Our Ref: 23/03489/PRIOR
Your Ref: 1 Cambridge Road

South Cambridgeshire District Council Application for Prior Approval

Proposal: Change of use of an office to a dwellinghouse including the installation of external stairs and the timber window to be replaced with painted white timber door on the south-west elevation.

Site address: 1 Cambridge Road Linton Cambridgeshire CB21 4NN

Status Planning	Title Location and Block Plan	
Client Name JR Crane Services	Scale 1:1250, 1:500@A3	Date 15/09/2023
Project Address 1 Cambridge Road Linton Cambridge CB21 4NN	Drawing Number 23111-0000	Revision P2

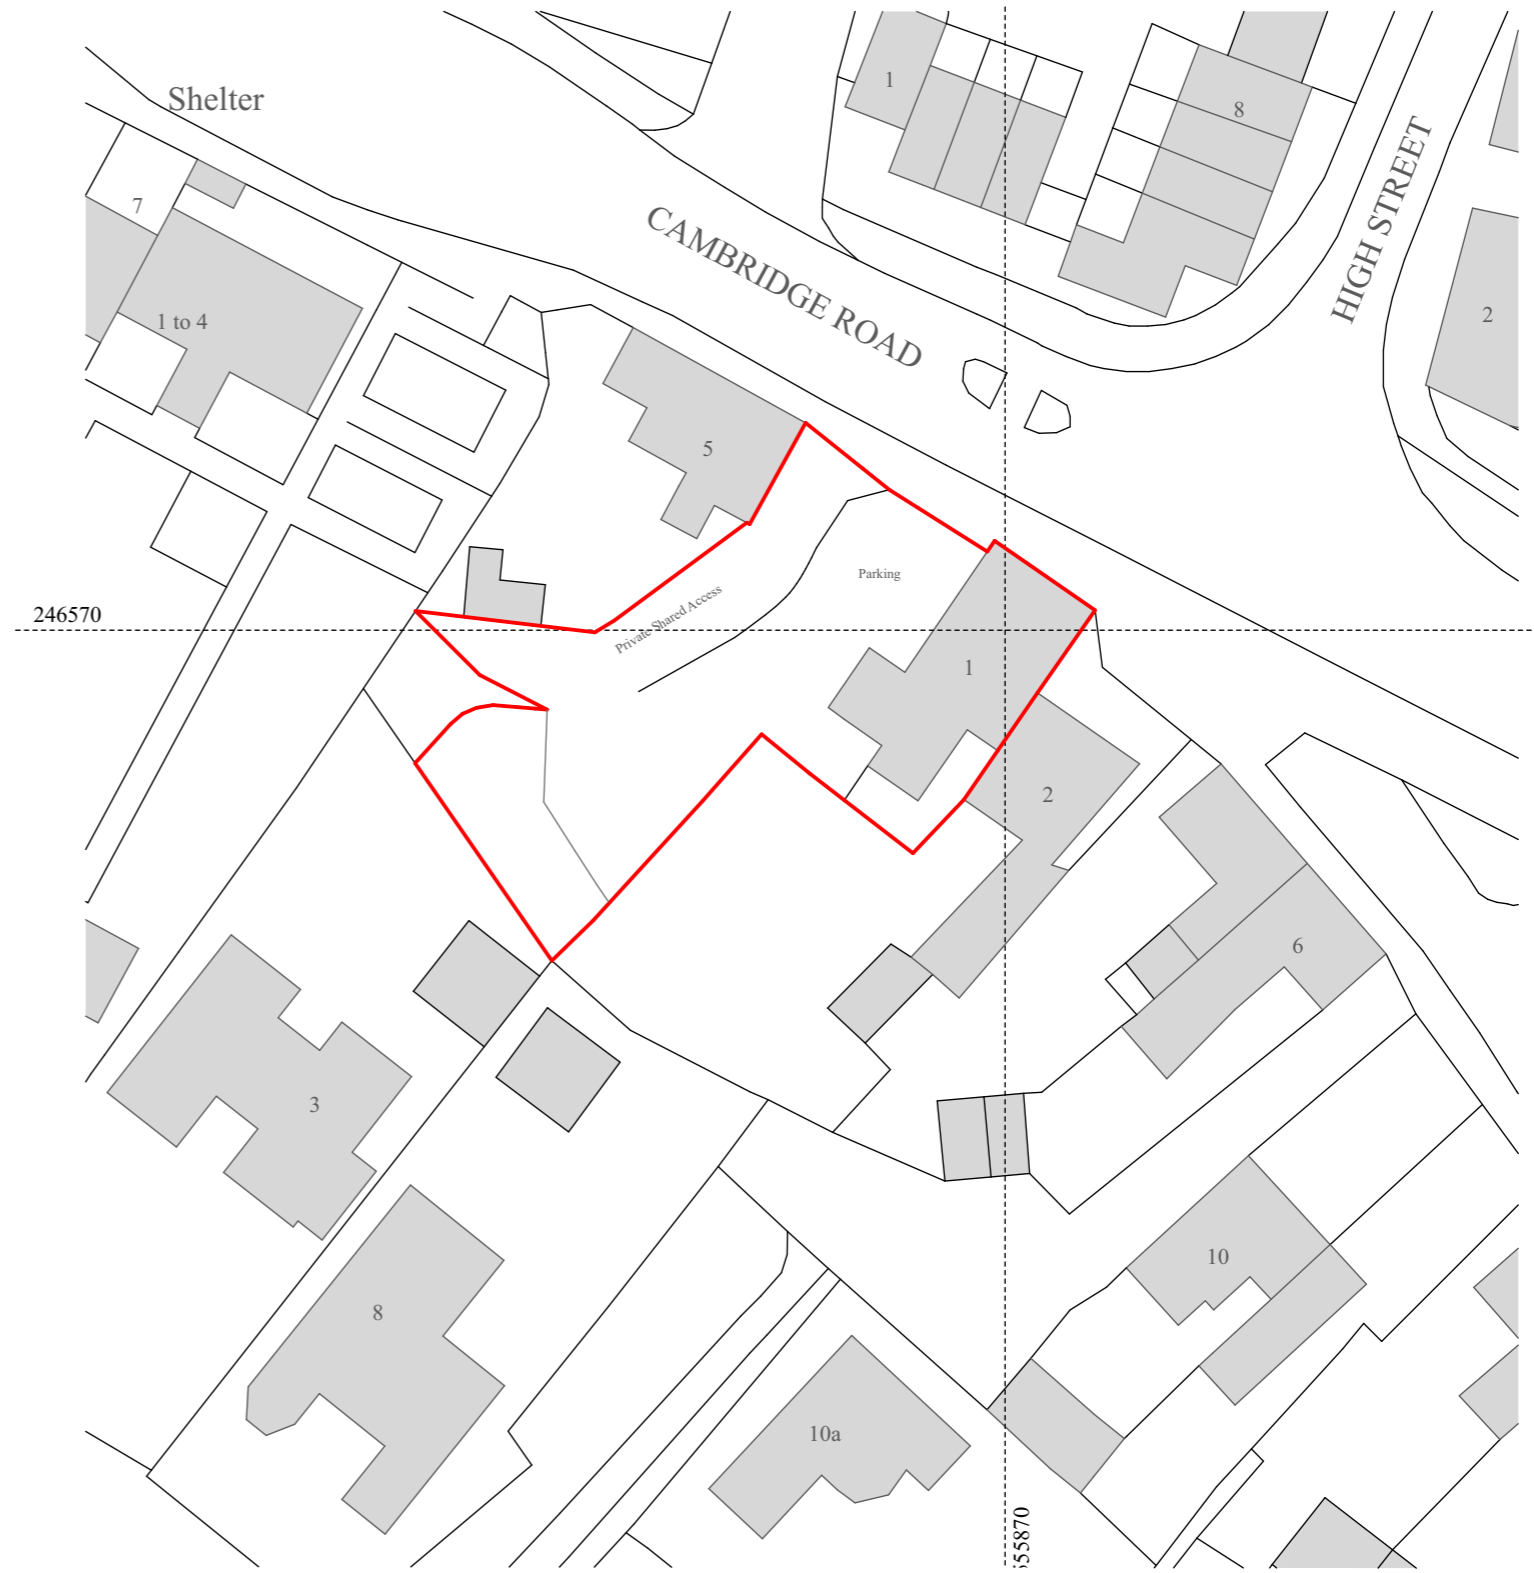
1. The Location Plan and Block plan differ, please confirm which is the correct red line, and resend.
2. External alterations are being added, therefore the fee is £206, we require an additional fee of £110. Please call 01223 457700 to make a card payment by telephone.
3. Please agree to the revised description of works.
